Ref: D2012/76601

Horsley Drive Business Park – State Significant Development (SSD-5169)

3 September 2012

**EROSION & SEDIMENT CONTROL PLAN**  
1:2000

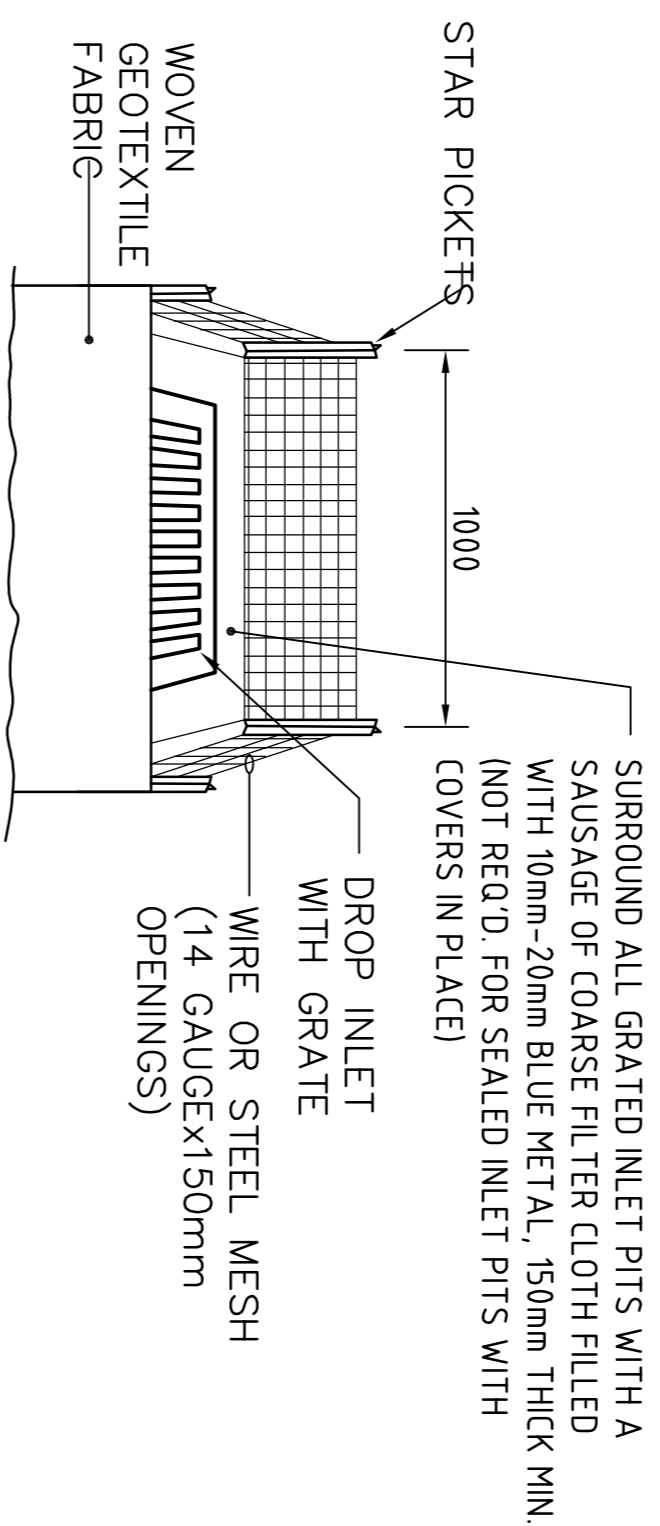
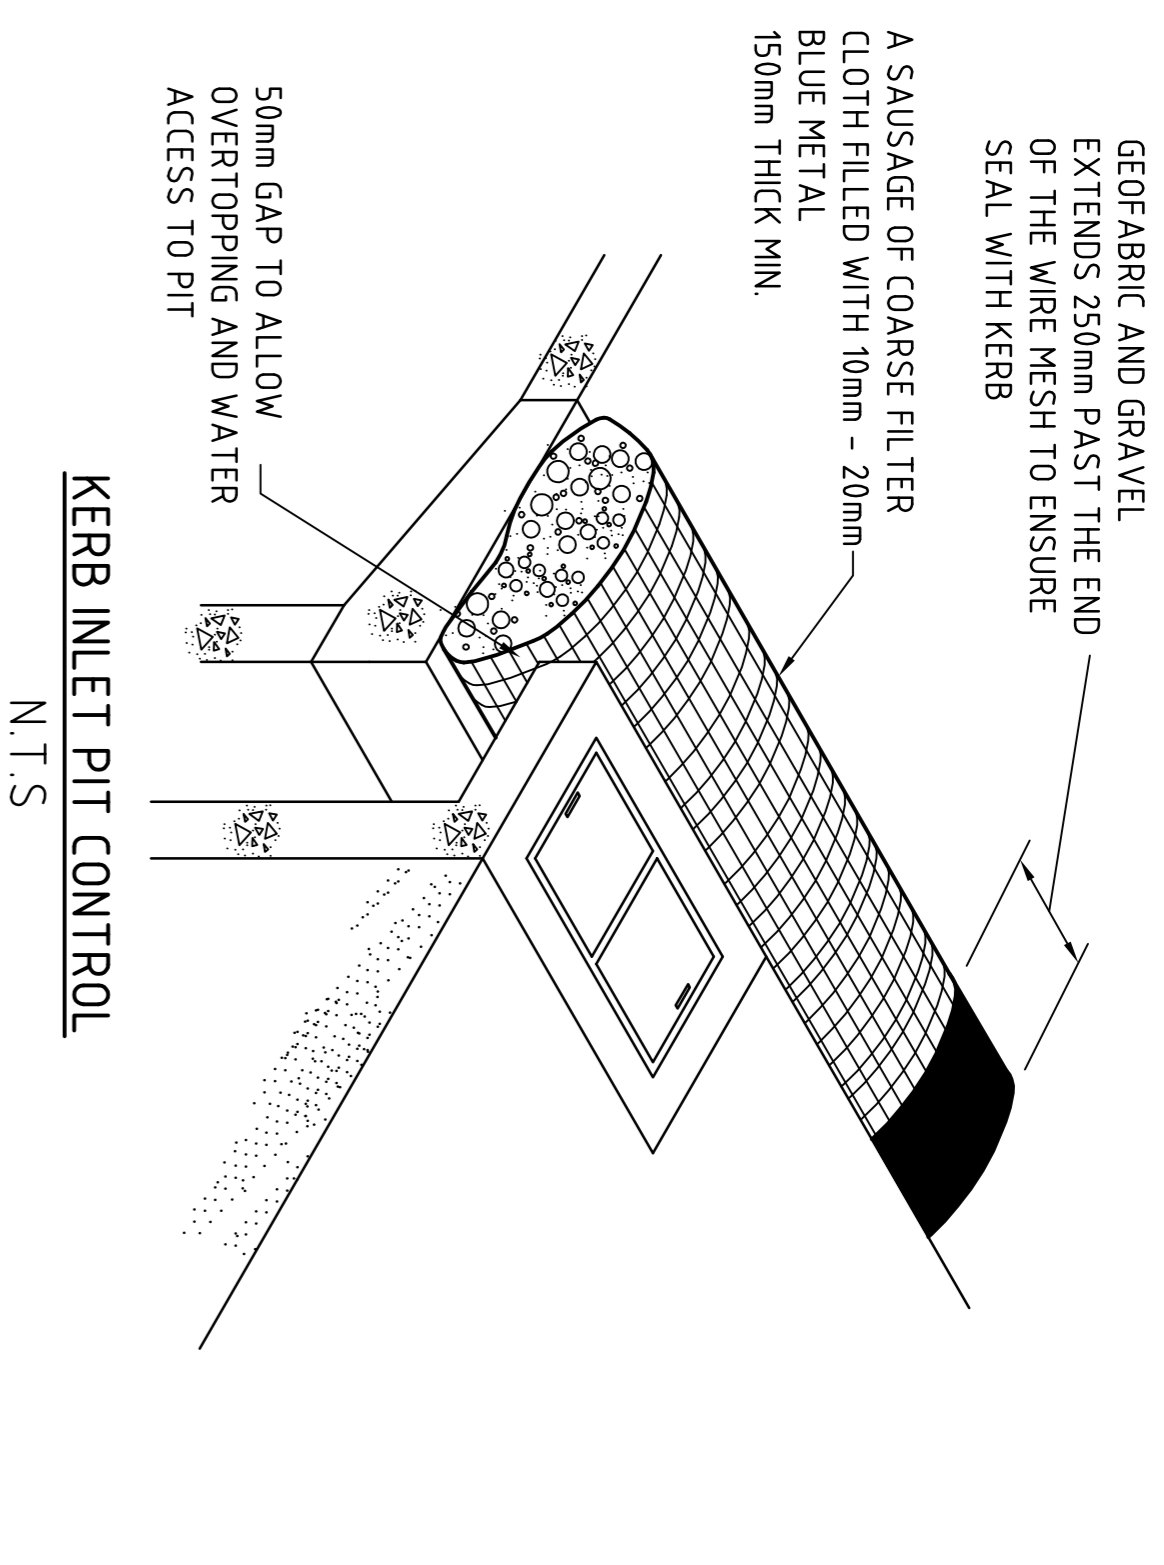
The Erosion and Sediment Control Plan shows a silt fence is proposed around the boundary of the site, including the boundary along the Upper Canal corridor to prevent sediment entering adjoining lands. As the works are occurring downslope of the Upper Canal, these controls are considered sufficient to prevent any impact on the water supply infrastructure.

EXISTING CATCHMENT SCHEDULE

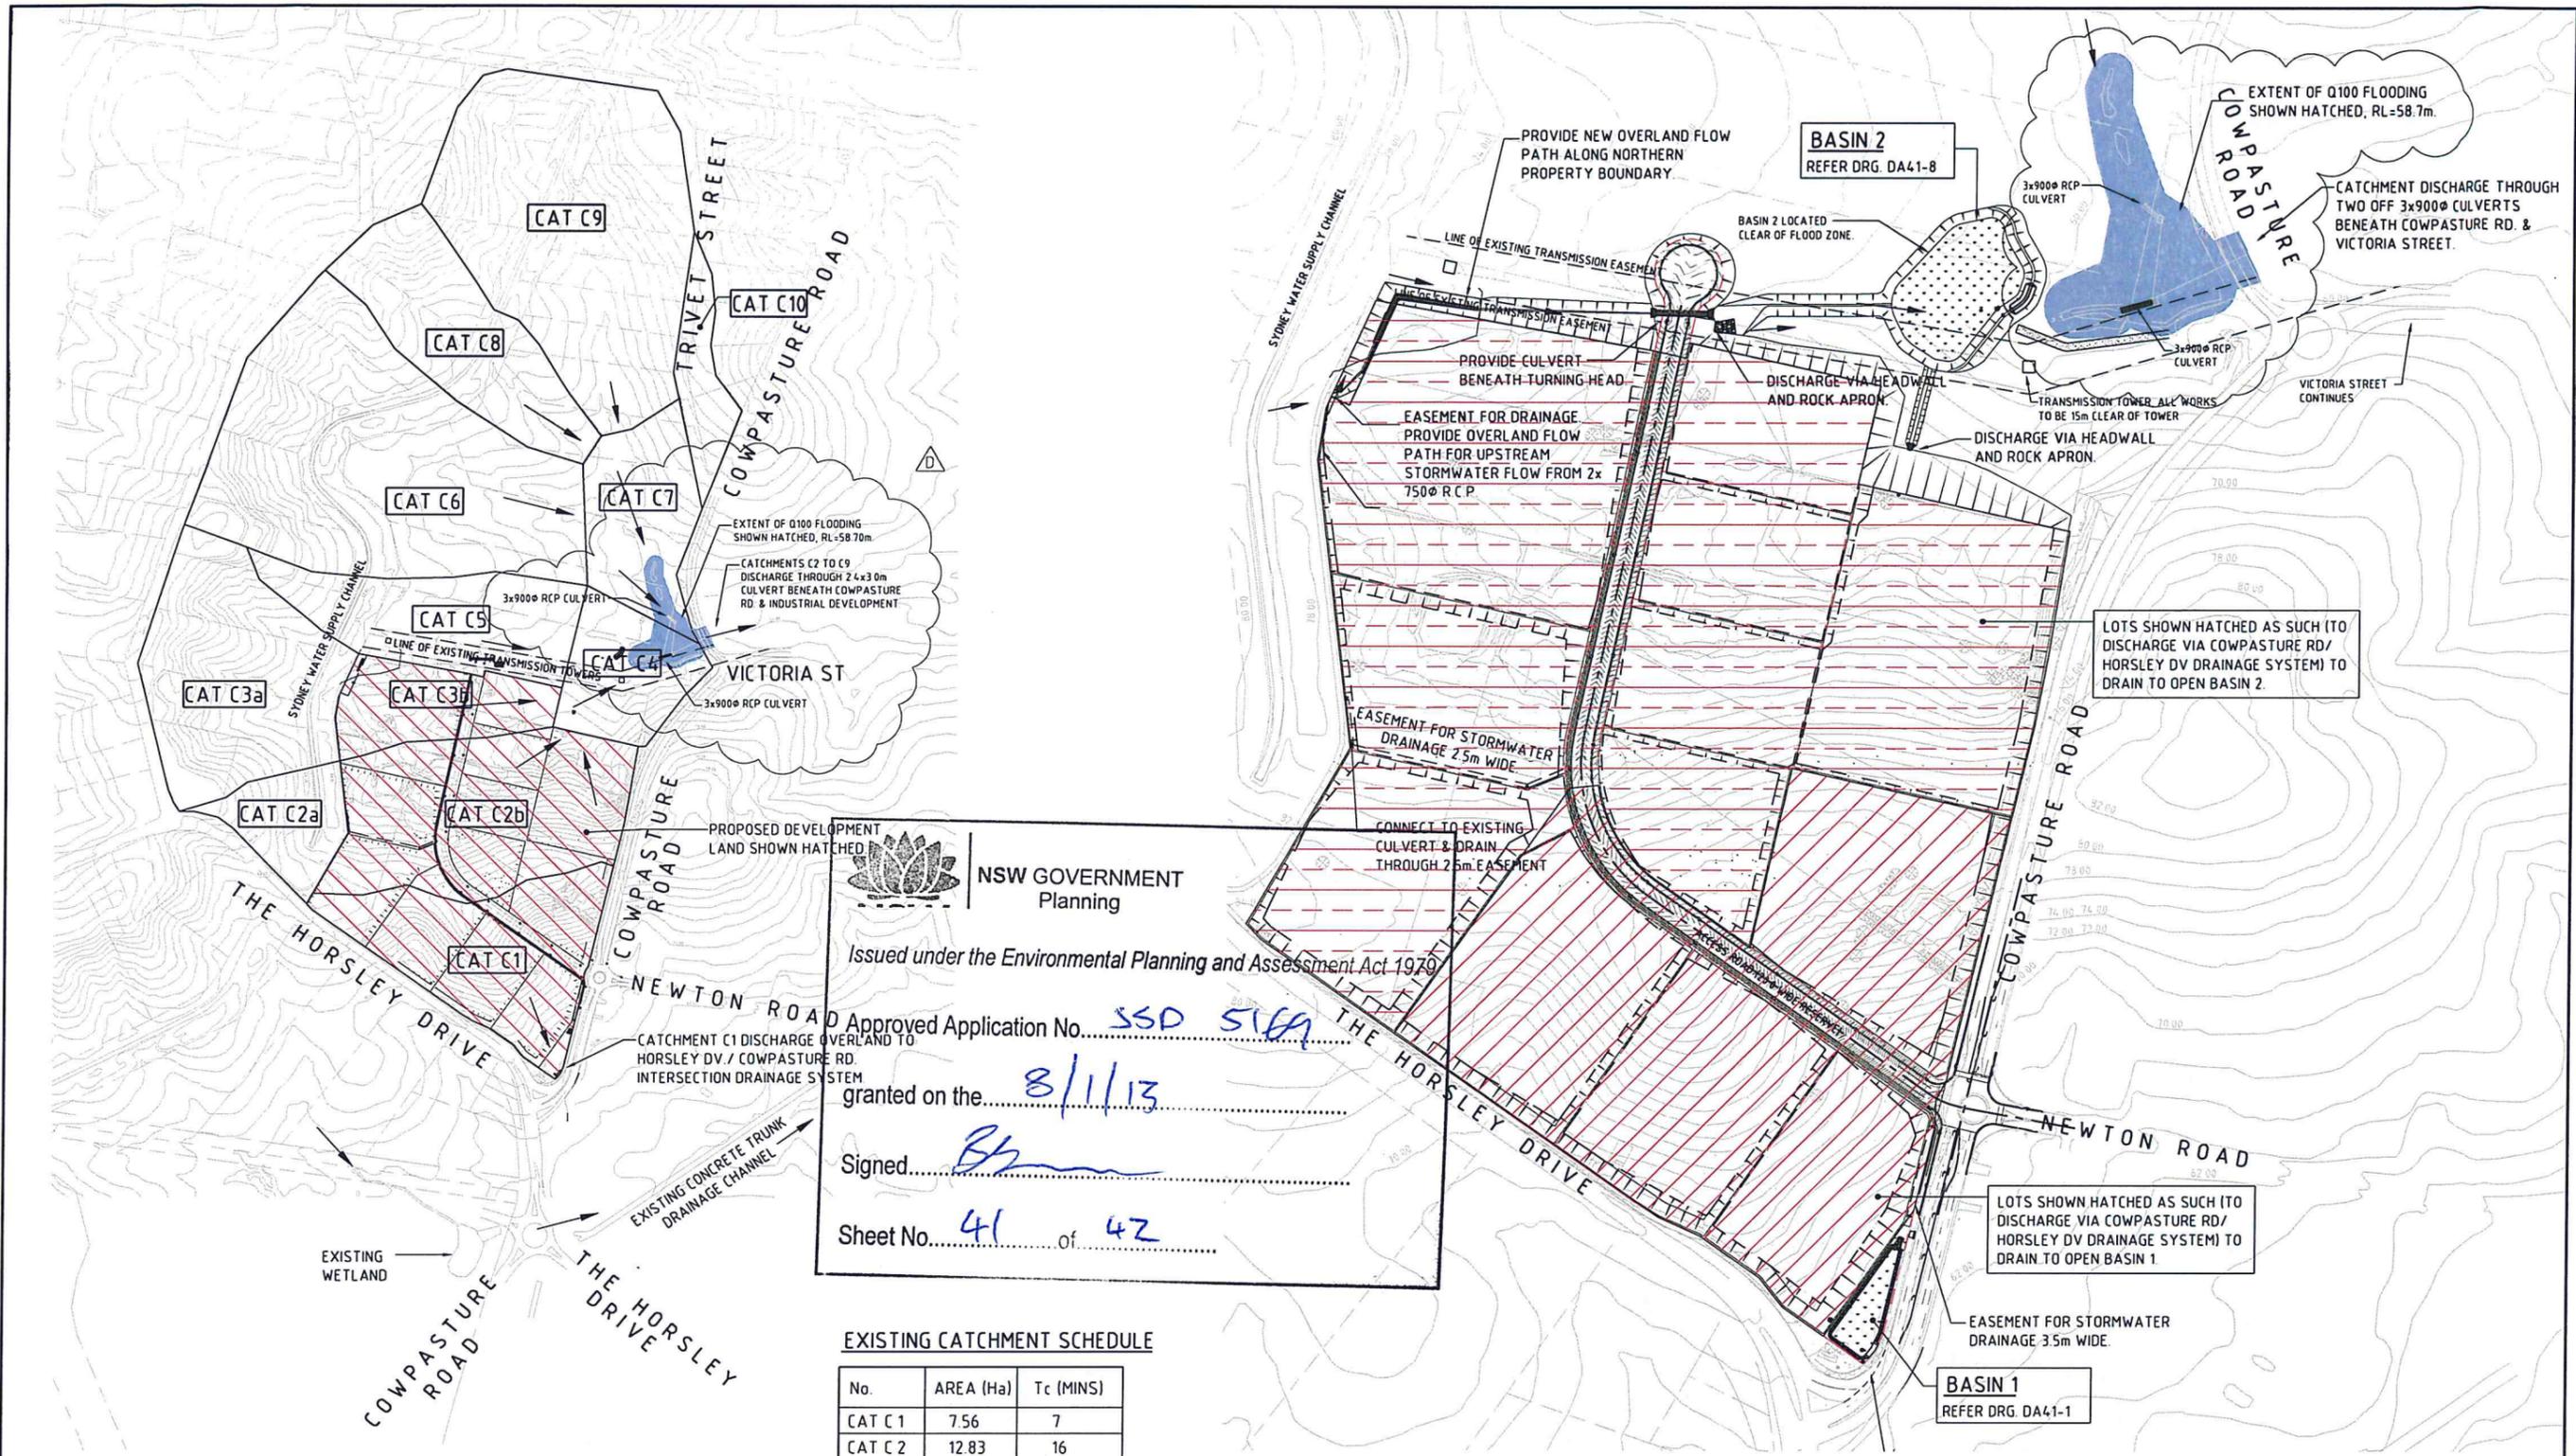
The Upper Canal is upslope of the development site and is therefore unaffected by stormwater flows from the site. The subject site is affected by overland flows emanating upstream of the Upper Canal corridor from catchments 2a and 3a (shown in the Existing Catchment Plan in Appendix 7).

The EIS considers the proposed piped stormwater drainage easement is sufficient to carry flows from the southernmost external catchment (2a) because flows from that catchment "will be blocked from entering the site by the Upper Canal so only minor flows are required to be allowed at this location." (page 14 Civil Engineering Report Appendix 6).

This statement is incorrect. Water is conveyed from the entire western side of the Upper Canal across the corridor and is discharged onto the subject site. There is also stormwater run-off from the corridor itself discharged onto the subject land. This stormwater system has been in place since the Upper Canal was constructed in the 1880s.

As stated in Condition 5 above, the stormwater management system should ensure that it makes allowance for all flow emanating from land to the west of the Upper Canal and from the corridor itself. This will require the proponent to reinvestigate whether the proposed piped stormwater drainage easement will be sufficient to accommodate those flows.

5. Stormwater systems shall be designed to accommodate and not impede upstream flows from any systems that convey stormwater across, along or under the Upper Canal. The stormwater management system should ensure that it makes allowance for all flow emanating from land to the west of the Upper Canal and from the corridor itself. The SCA shall be provided with details of these stormwater systems located along the SCA boundary before such works commence.
